Building Code of Australia 2019

Report for BCA Compliance

PROJECT NAME: The new Sydney Fish Market (SSDA Review Stage)

DATE: 26.09.2019

FLOOR PLAN MEZZANINE

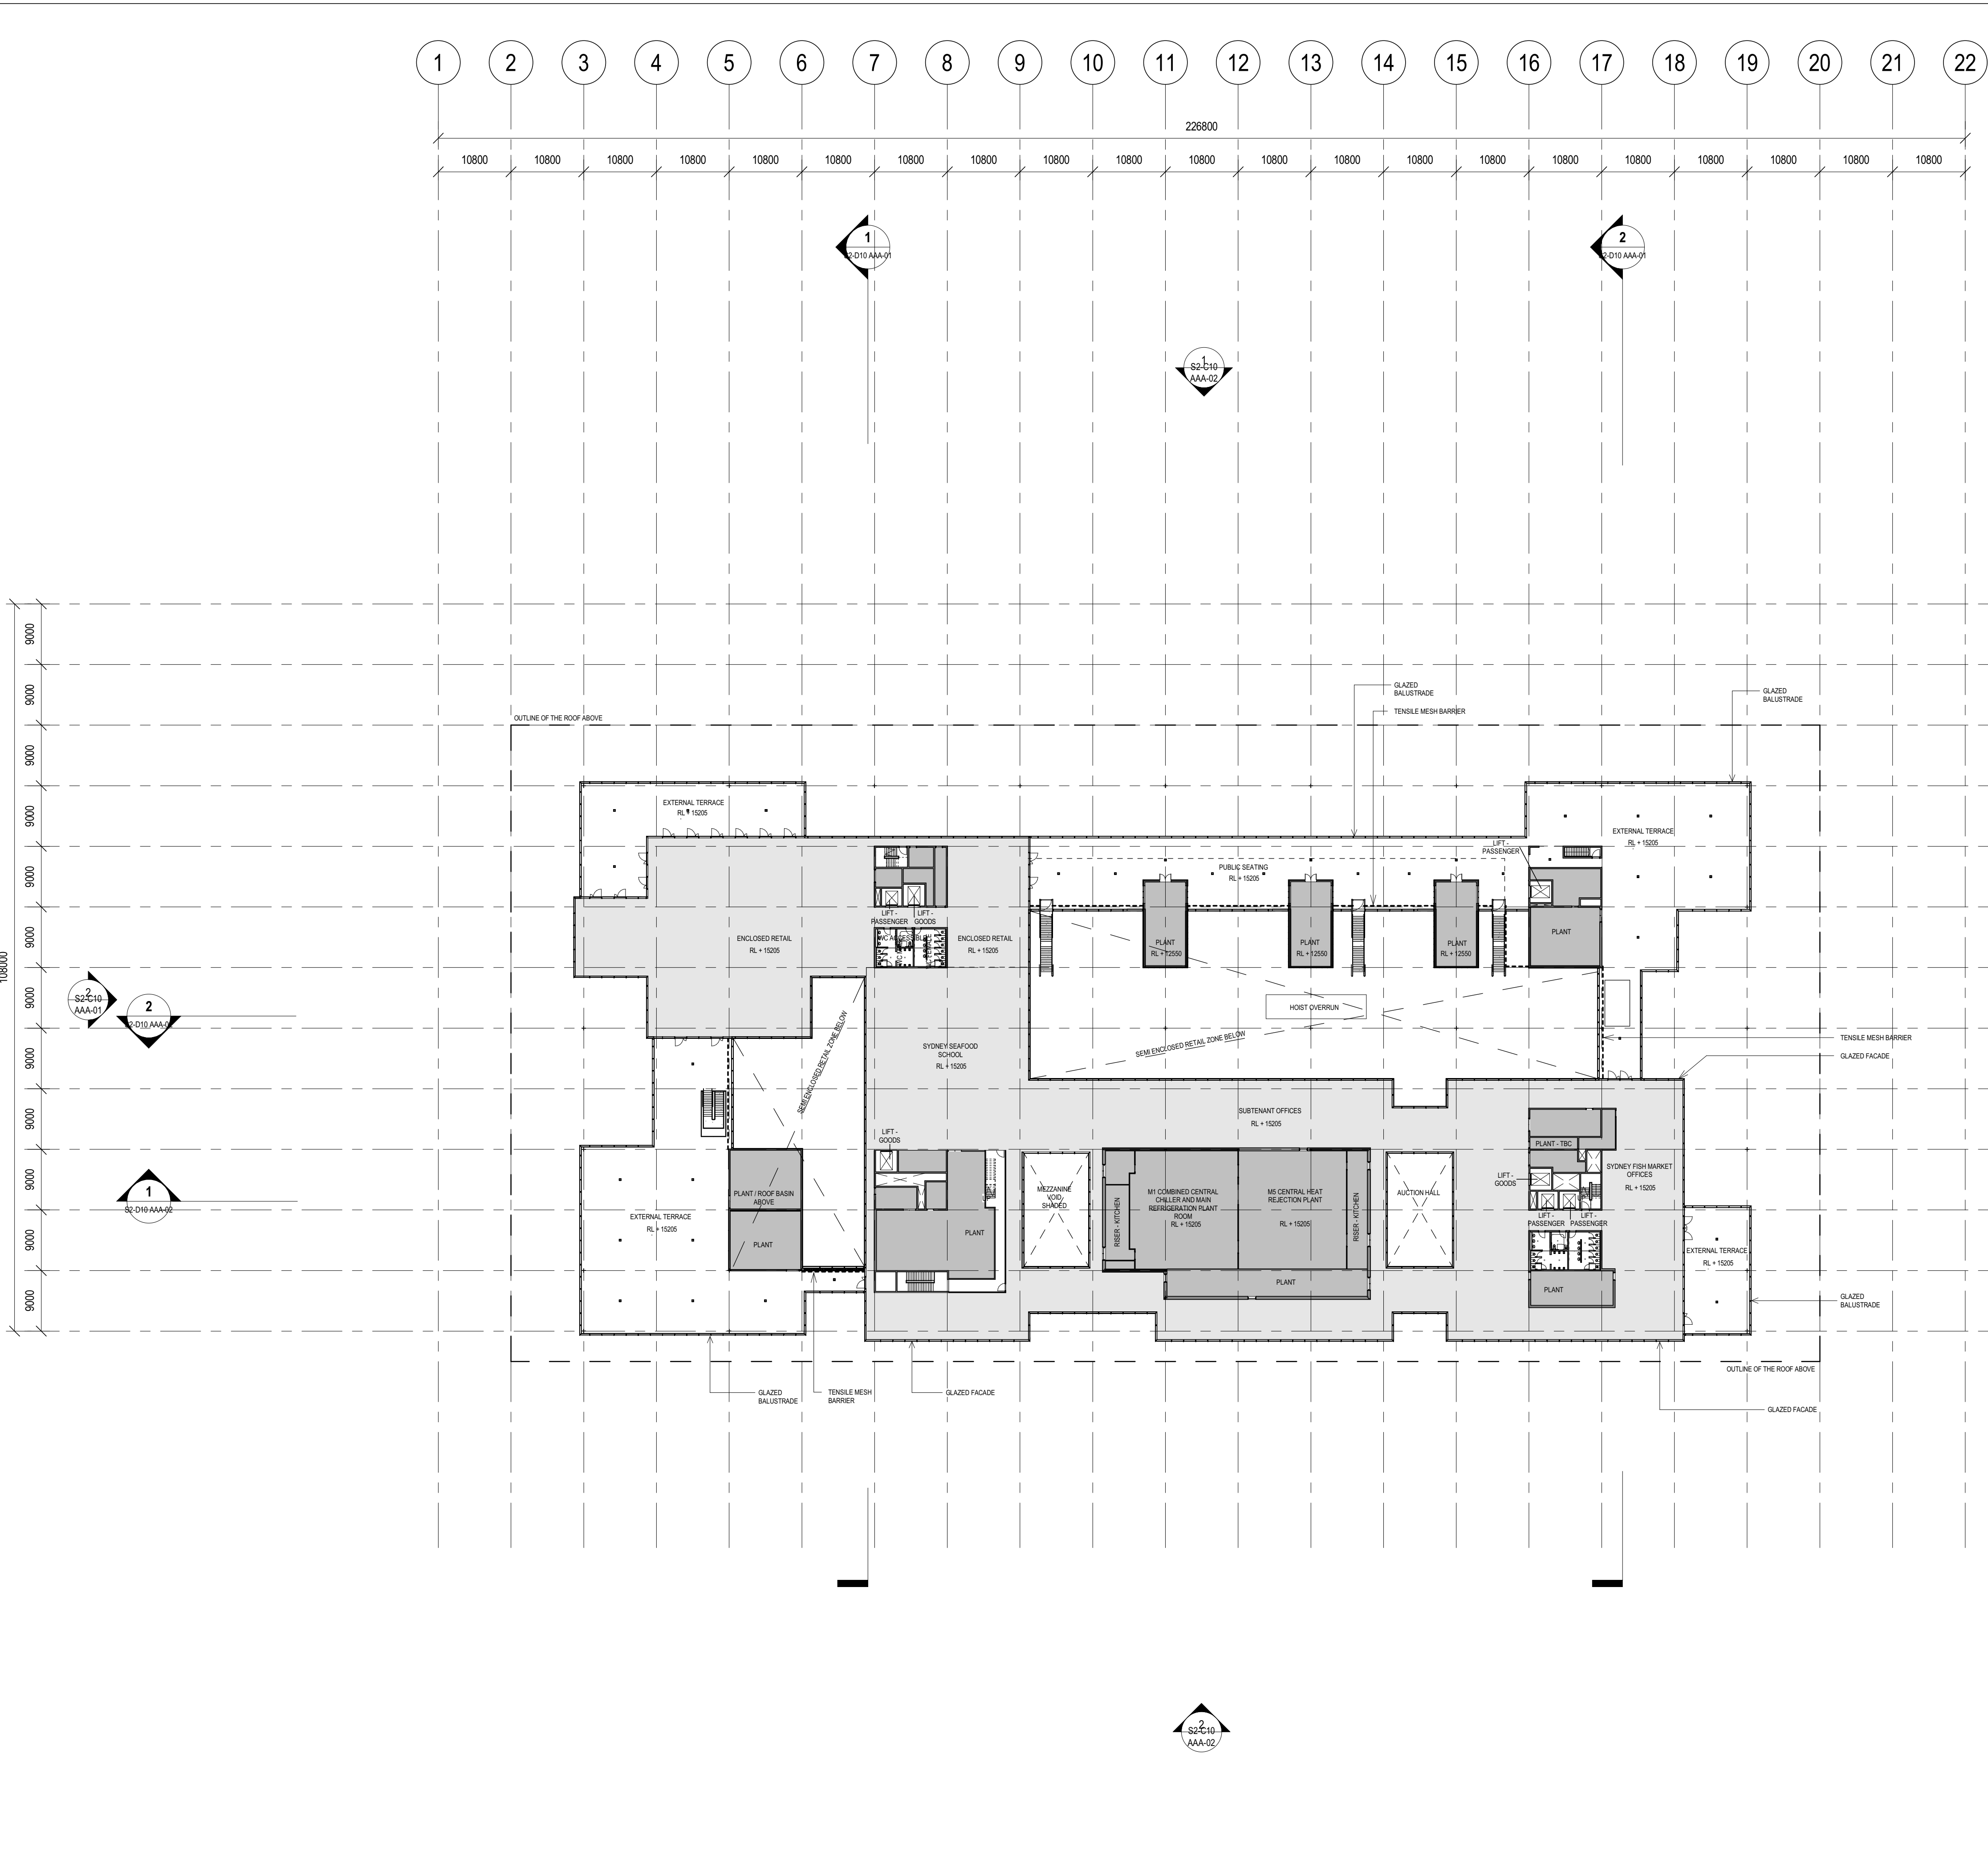
Firewalls are needed to separate different building classifications, or the building must be built to the higher fire resistance level. The fire walls are to achieve the required FRL and constructed according to this clause. However, no evident walls are proposed to separate the different building classes (different uses).

Fire walls in accordance to Table 3 of Specification C1.1 are required. See mark up in Appendix C as guidance.

Compliance is achievable through a Fire Engineering Performance Solution being prepared by Aecom that will address this matter.

AUCTION & OFFICE SECTION

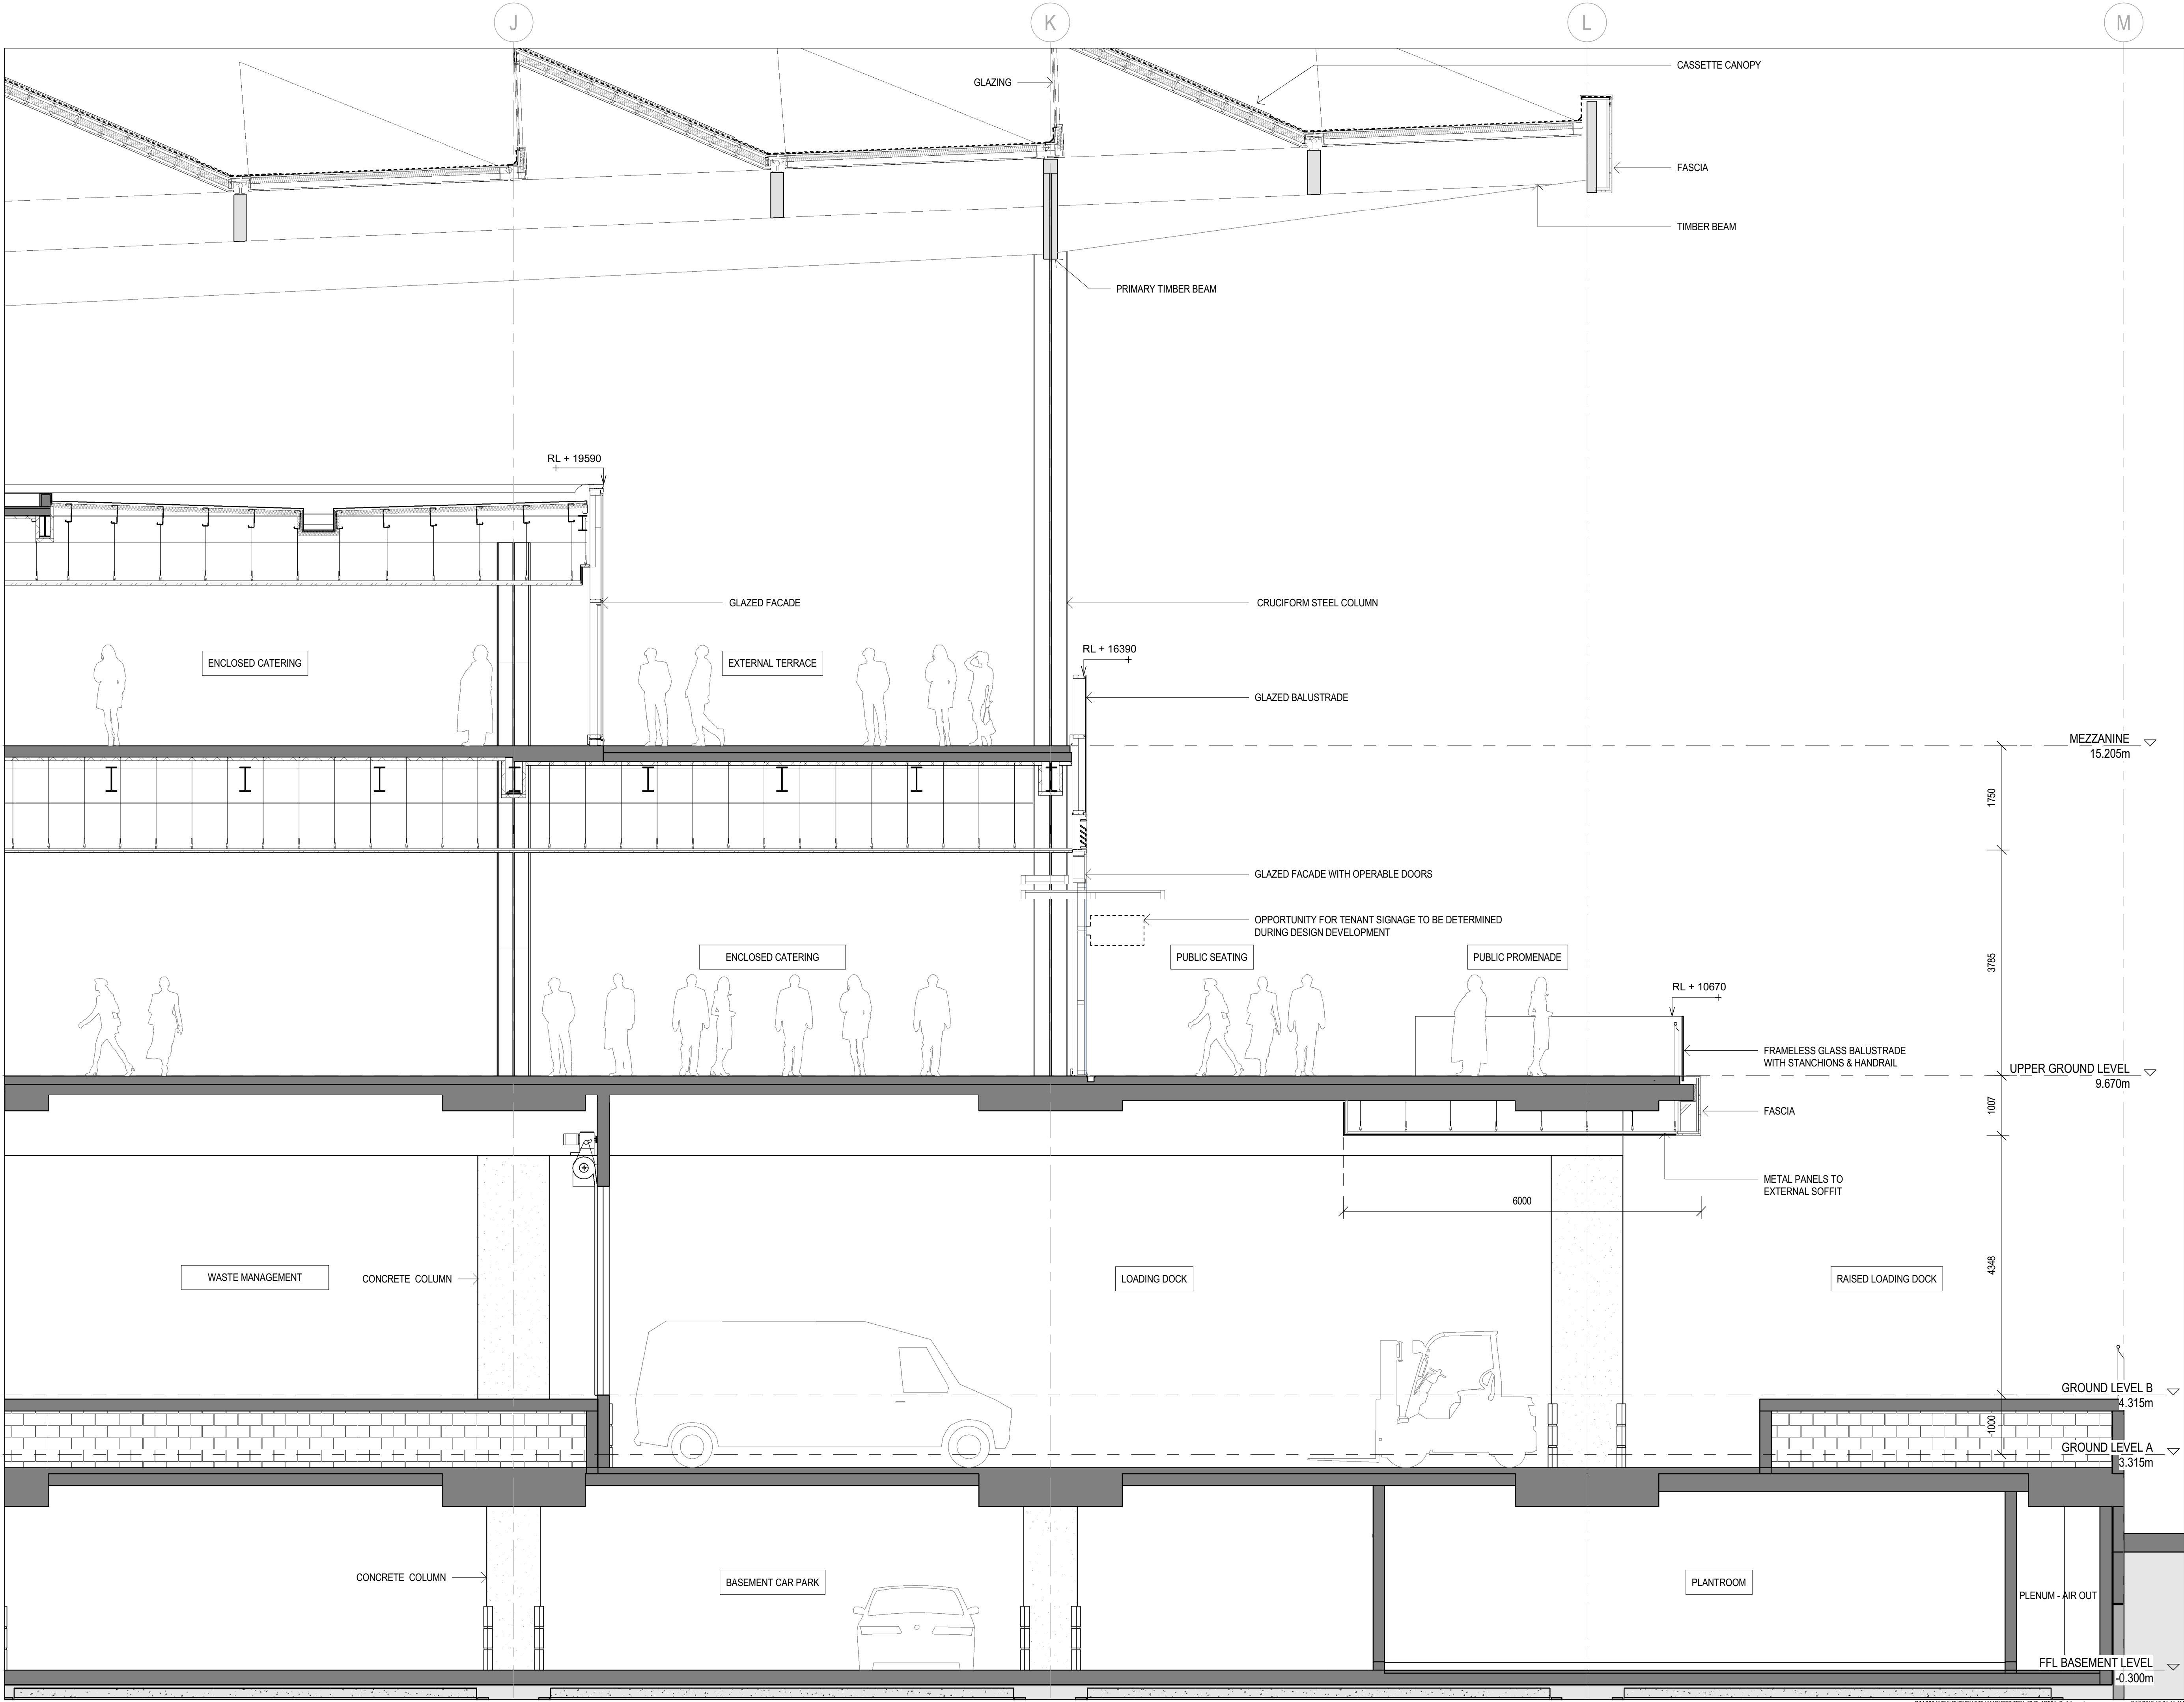
19.	Provision of insufficient Atrium G3 construction in Auction Hall	Performance Solution is currently being undertaken by the Fire Engineer (Aecom)	G3 Table E2.2a	EP2.2

24.	Non-compliant stair layout comprising more than 18 risers per flight in the Auction Hall	Performance Solution is currently being undertaken by the Ergonomic Consultant (Mark Dohrmann)	D2.13	DP2 DP6

25.	Non-compliant handrails type provided in the Auction Hall	Performance Solution is currently being undertaken by the Ergonomic Consultant (Mark Dohrmann)	D2.17	DP2 DP6
